STATE OF NORTH CAROLINA
DEPARTMENT OF TRANSPORTATION

Addendum No. 1

RE: Contract ID: C201326
WBS# 38724.3.1
F. A. # IMS-095-1 (59) 22
Robeson County (I-4711)
I-95 From US-301 (MP 22.1) to
The Cumberland County Line.

February 21, 2006 Letting

### TYPICAL SECTION NO. 2

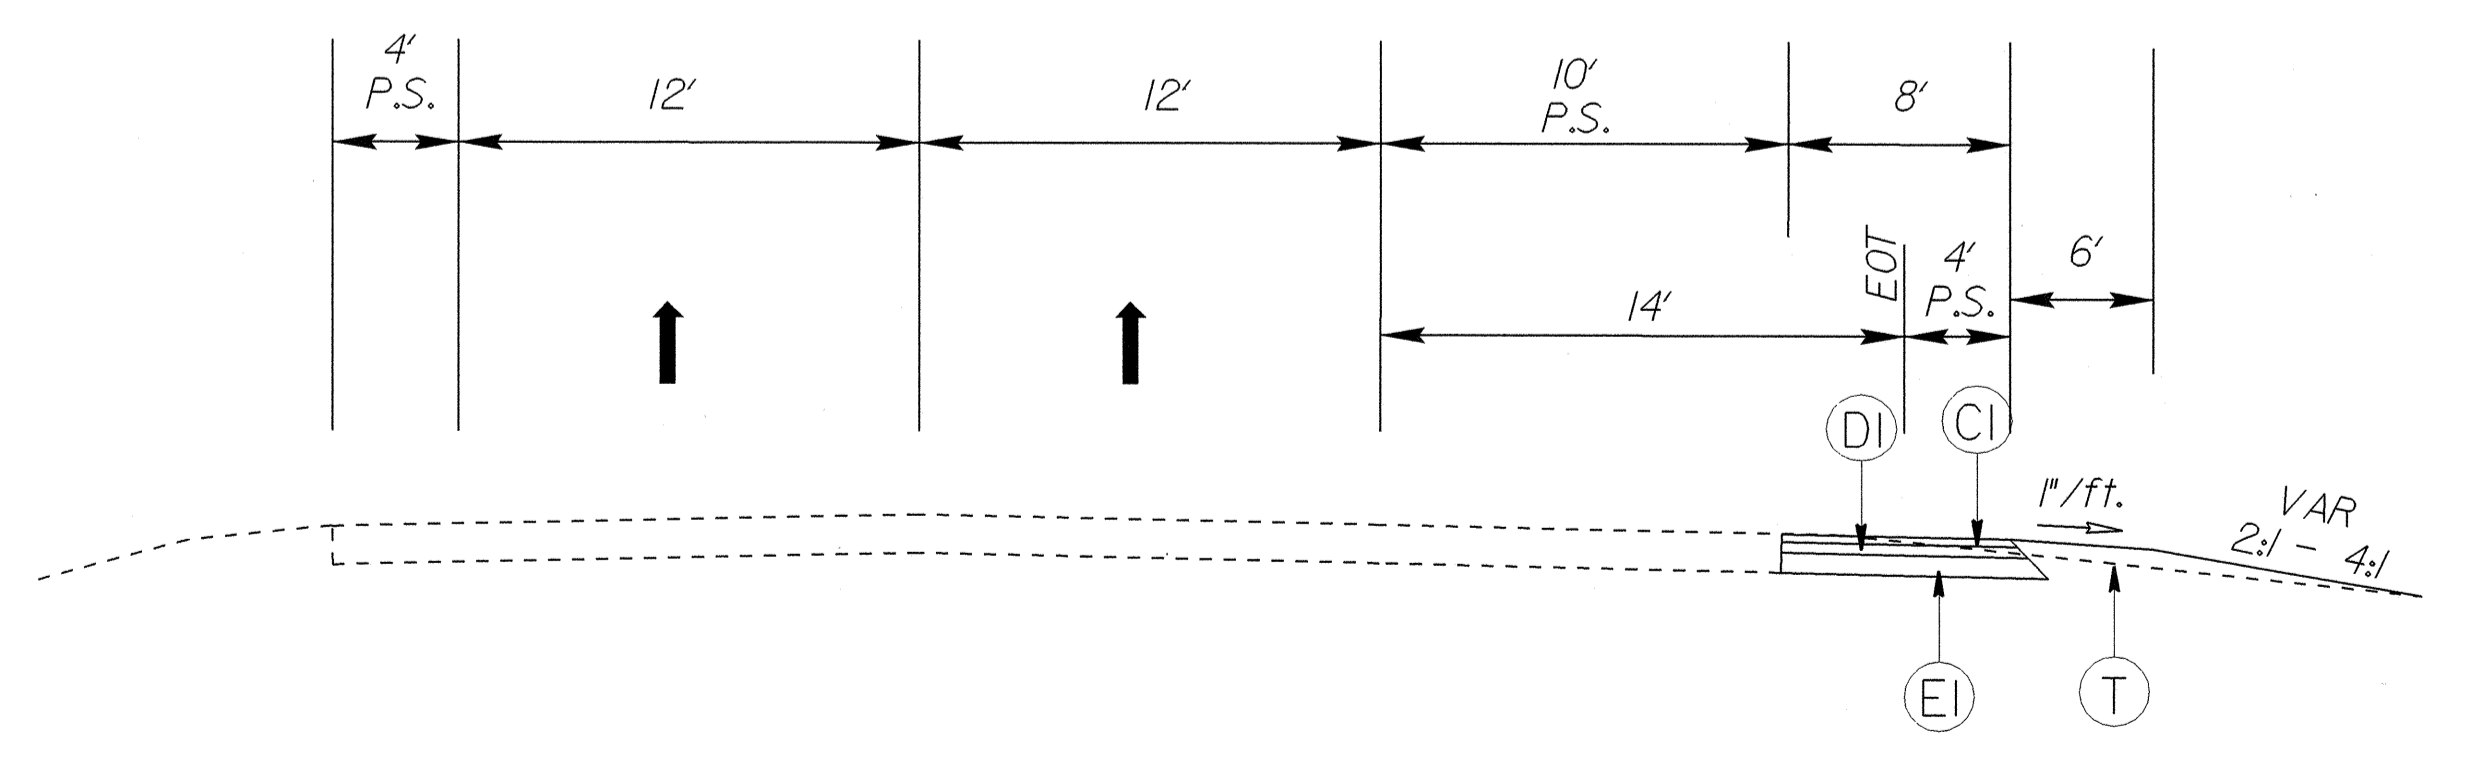
Sheet No. 2 has been revised to change Typical Section No. 2 to include milling the paved shoulders. Please void Sheet No. 2 in your plans and staple the revised Sheet No. 2 thereto.
